Application No. 2011/1057

REFERENCE: PROPOSED CHANGE OF USE TO INCLUDE B2, JUMBO SELF DRIVE LTD.,  
2A SHEFFIELD ROAD, BIRDWELL, BARNSELY. SOUTH YORKS. S70 5UZ.

Scale: 1/250 @ A3. Dwg. No. SRB/YDL/03A.

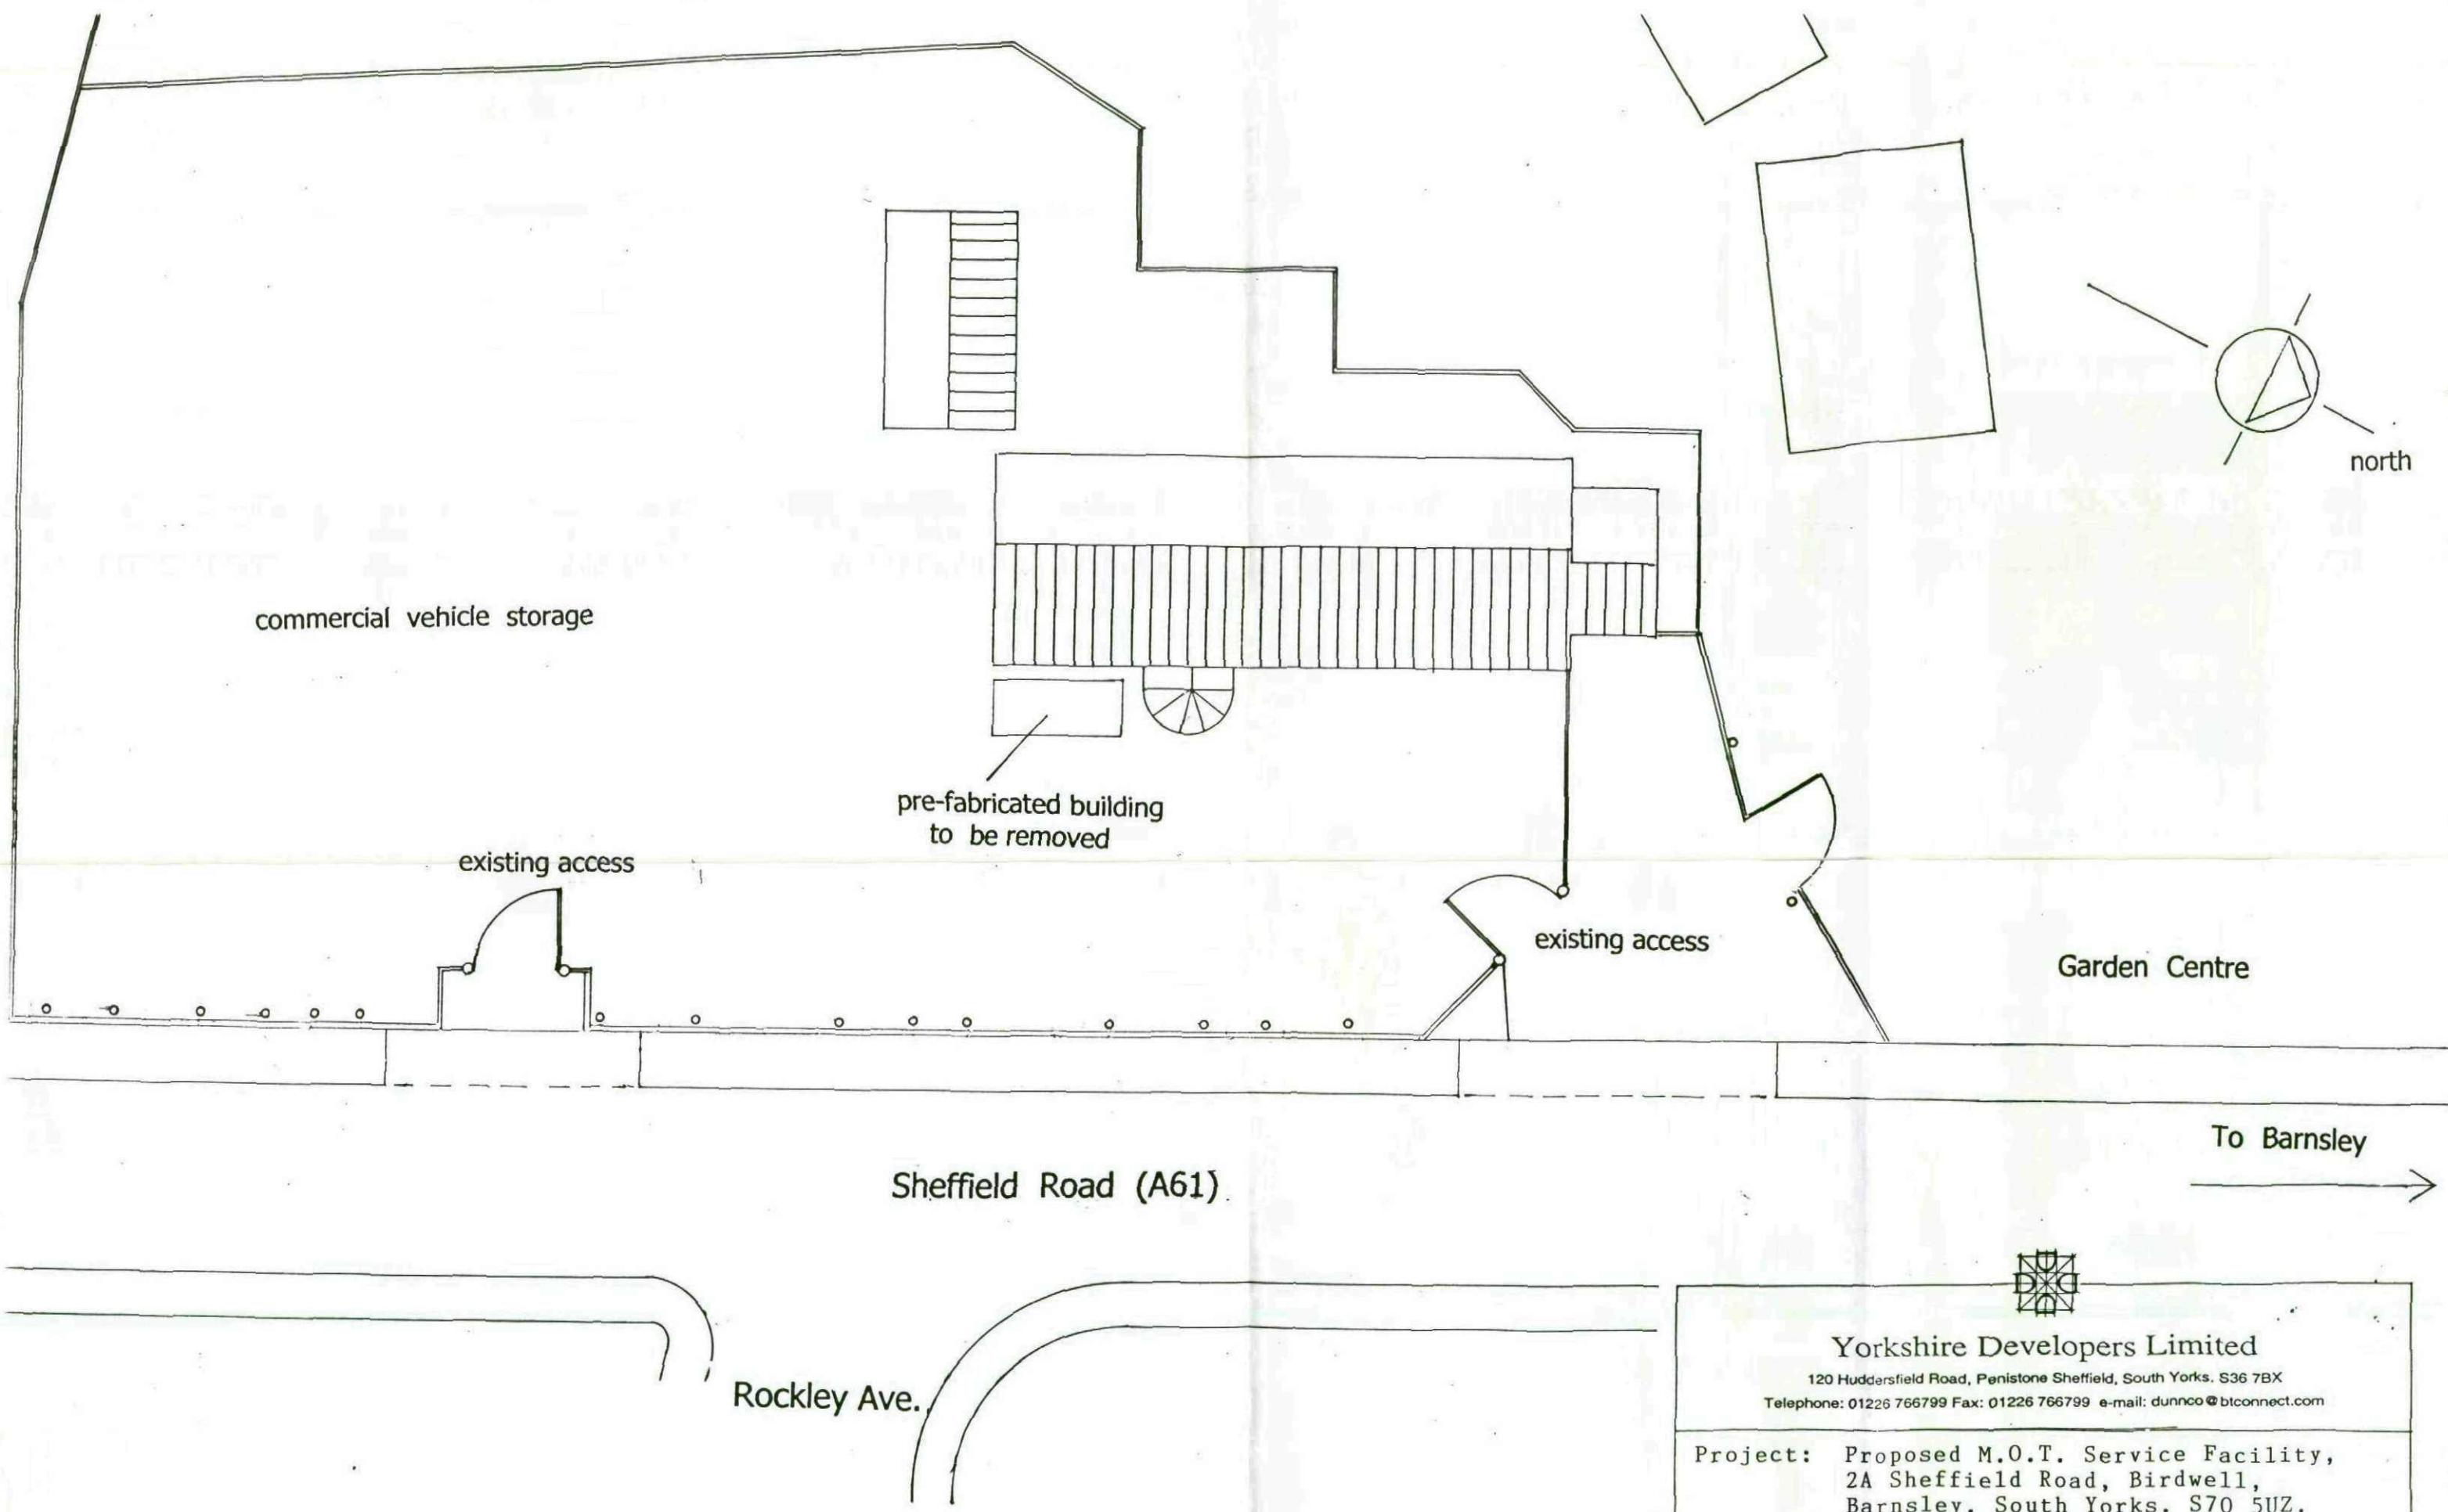
With reference to the Comments made by Mr. Ellam, I confirm:-

1. The access/egress from the subject premises is capable of having the visibility splays as requested without the security fence being moved because behind the 1.80 m. footpath is a 0.30 m. landscaped area in front of the security fence.
2. The vegetation will be removed and maintained to achieve the above visibility splays.
3. Existing access no. 1 will be used for vehicles entering the commercial parking area and these and other vehicles will be able to leave through the new security fence via the sliding gate between the commercial parking area and the M.O.T./Service facility.
4. With regard to the long term future of the substandard access, the owner has been made aware that if there is an increase in traffic flow, he will have to make improvements to this access as required by Environmental Services.
